Department of Planning and Environment

11 April 2022

Kemps Creek Data Centre (SSD-10101987) Request for Additional Information – Construction Traffic

Figure 16: Construction Traffic - AM peak hour net traffic volumes

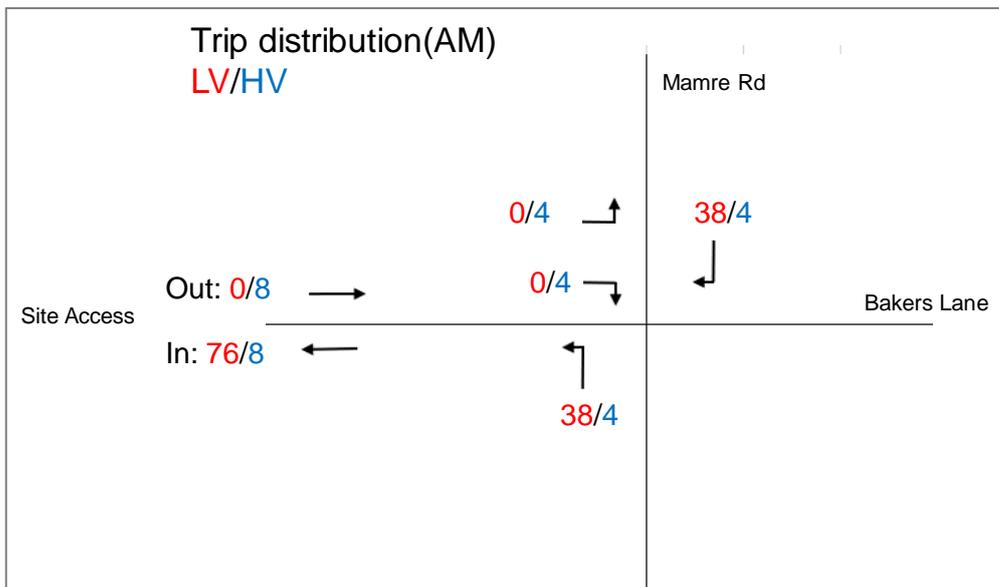
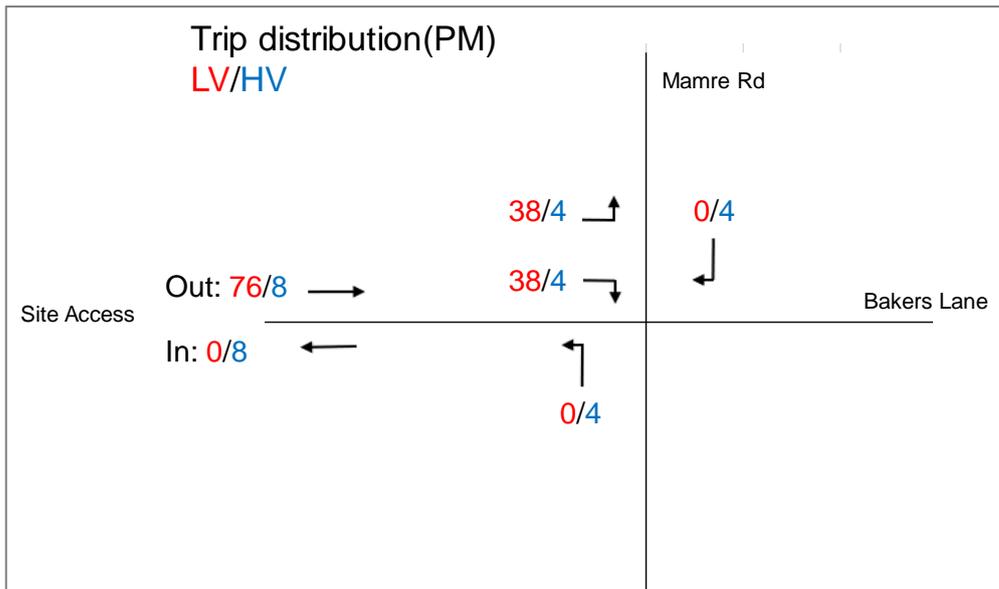
- Your Environmental Impact Statement does not include an assessment of cumulative construction traffic impacts on the regional and local road network.

Figure 2: Construction vehicle access routes

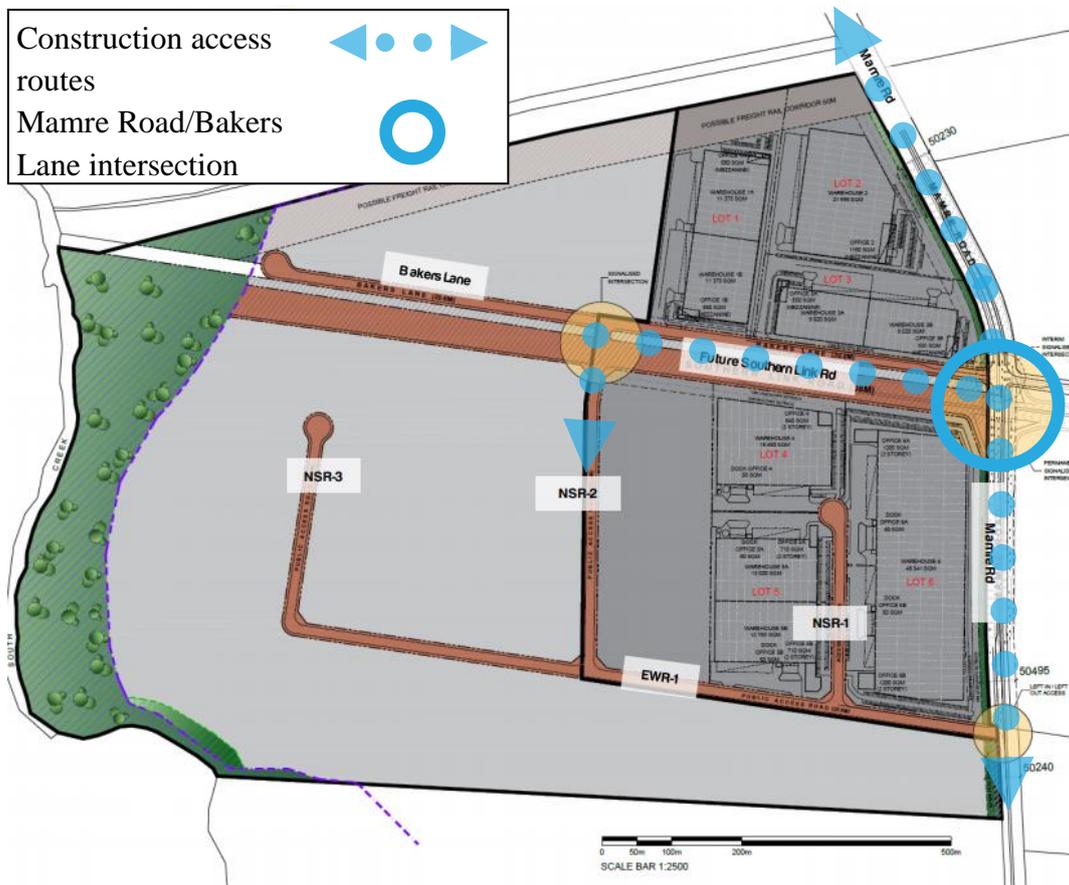
- You are requested to provide detailed information on proposed the staging and delivery of the construction of your development for consideration prior to determination of your application. This should include the timing of necessary external road upgrades as well as construction works on your site. Clarification is sought on what temporary road upgrades may be required to accommodate construction traffic.

- Details on how construction traffic may impact on the delivery of road infrastructure in the precinct is required, particularly if these road infrastructure works are being undertaken at the same time your project will be generating construction traffic.
